# CITY OF ALBUQUERQUE

**Re: ARMC Site Renovations, Walter St. Grading and Drainage Plan**  
**Engineer's Stamp dated 9-28-05 (K15-D6G)**

Based upon the information provided in your submittal received 10-03-05, the above referenced plan cannot be approved for Grading Permit until the following comments are addressed:

SHEET TITLE:
OVERALL SITE
GRADING PLAN

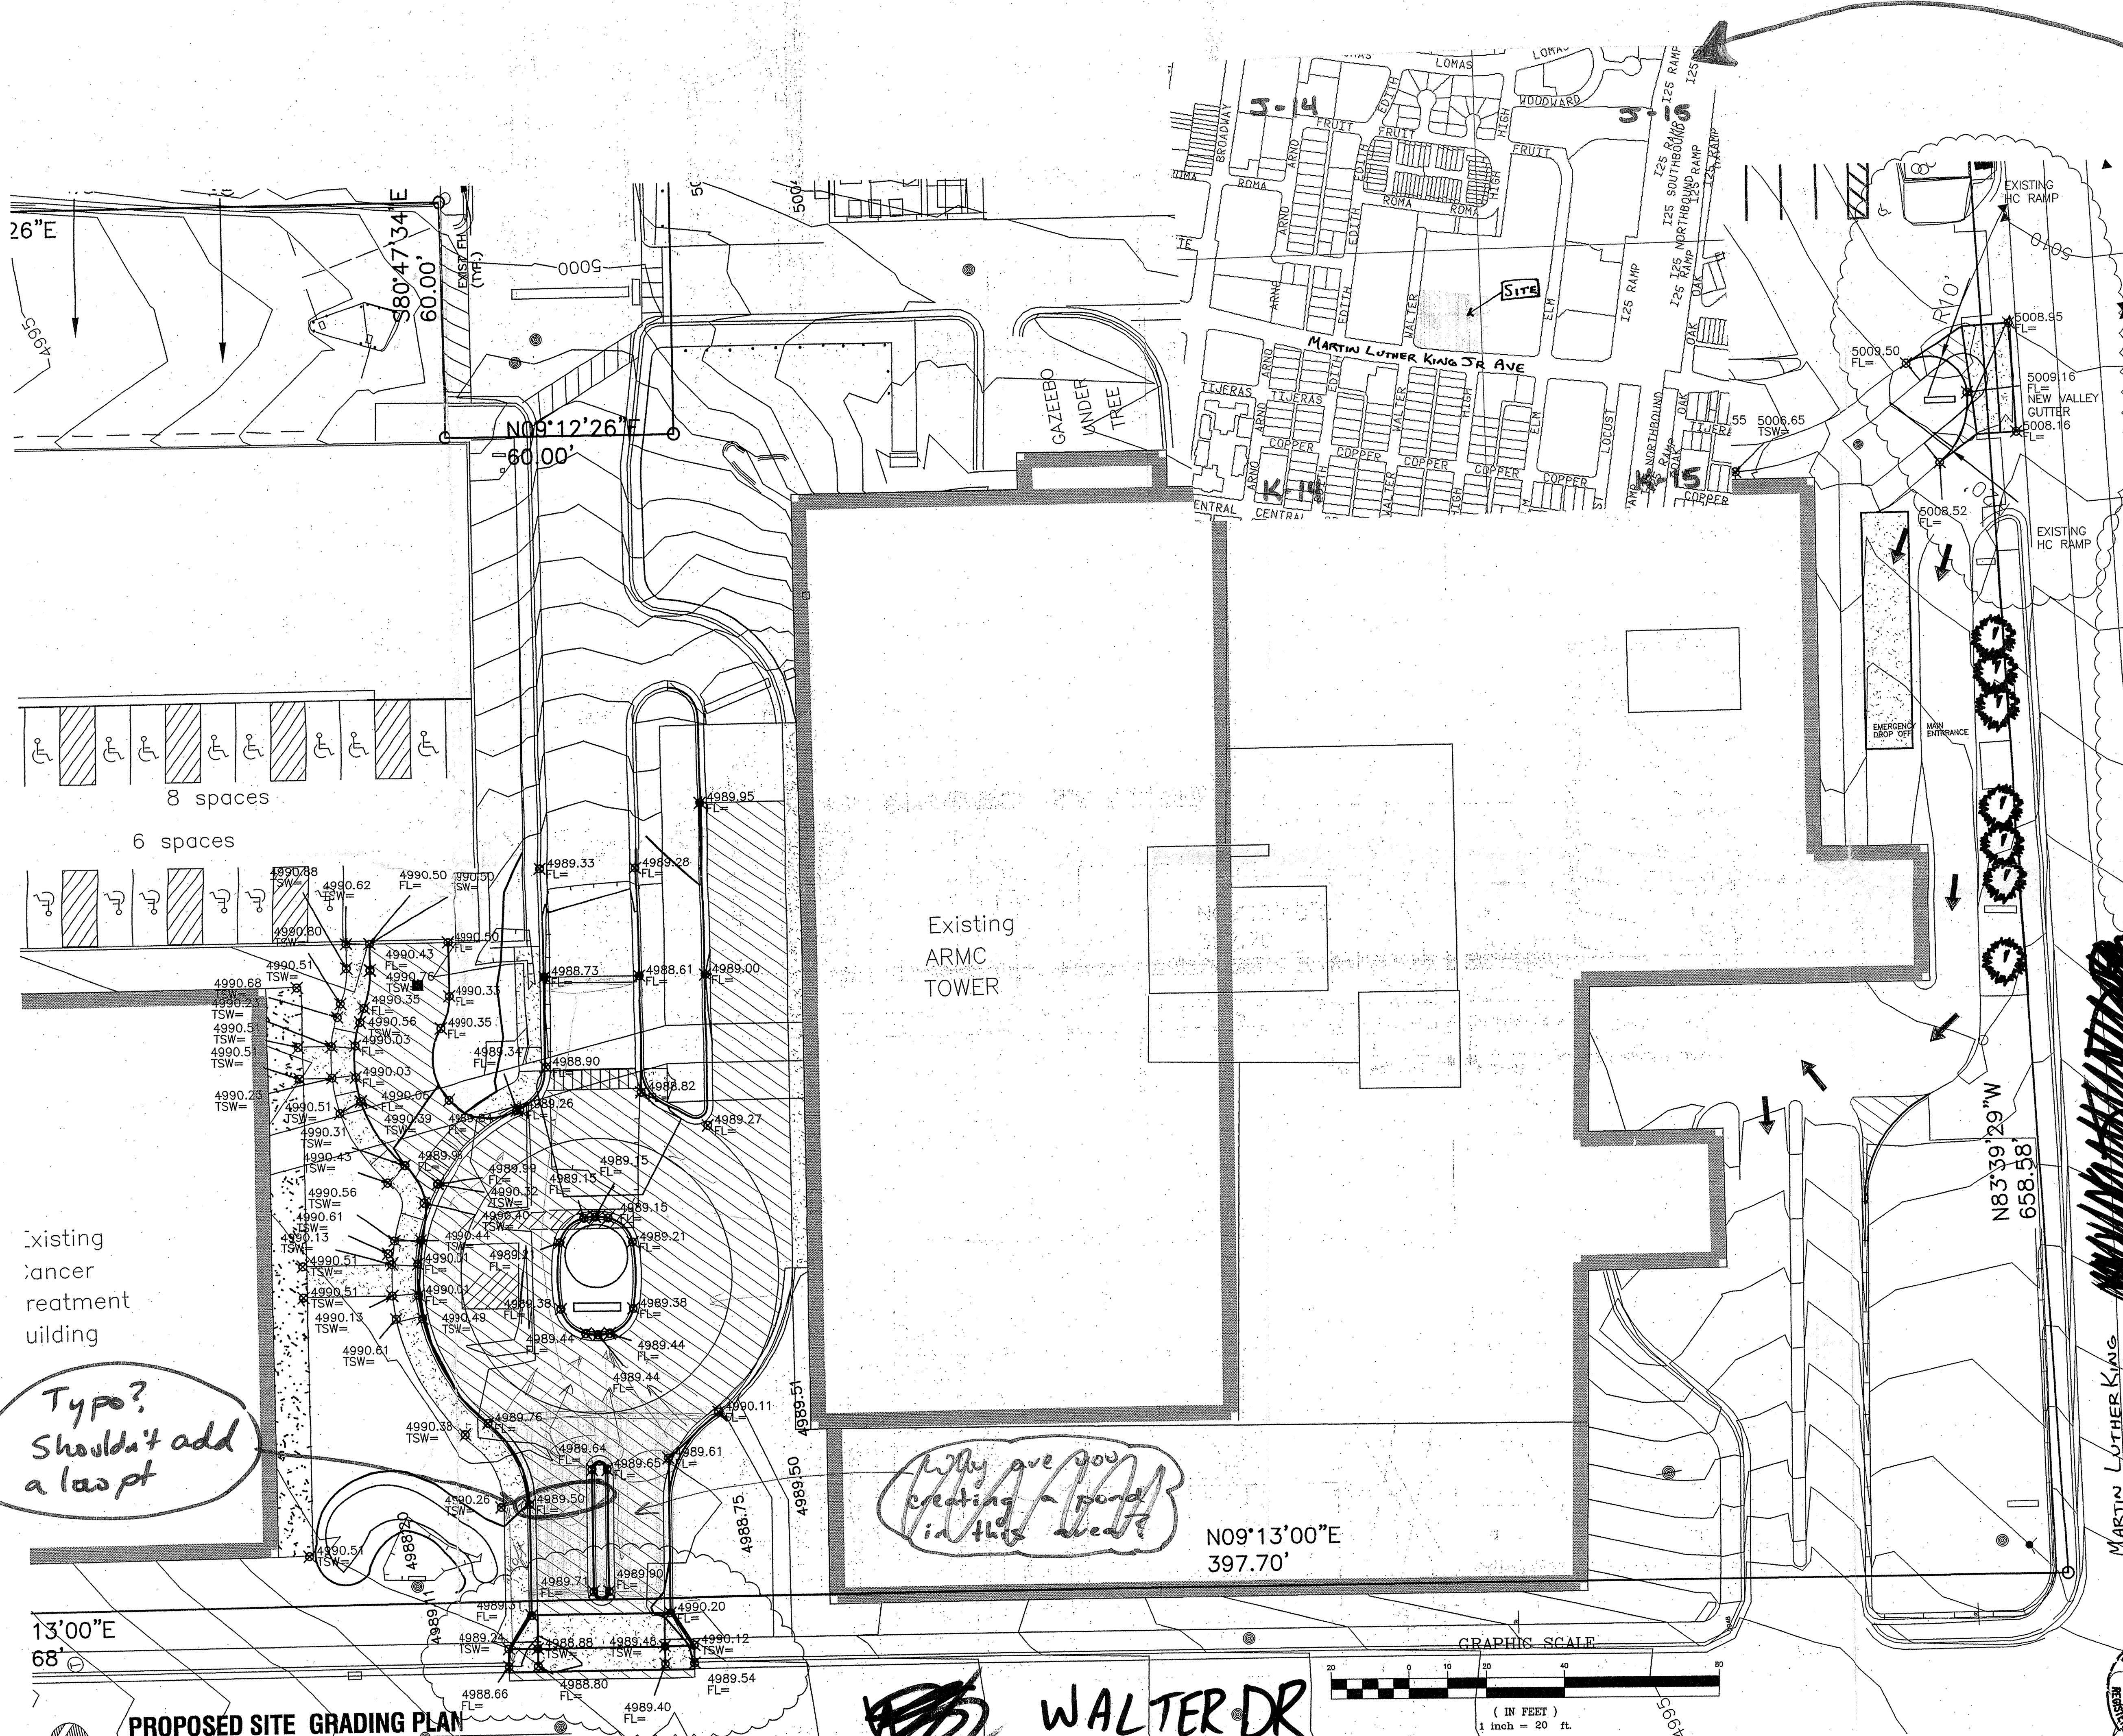
1. Show all proposed and existing drainage infrastructure. How will the low spots drain?
2. A narrative would be helpful in lieu of drainage calculations.
3. A legend would also be helpful.
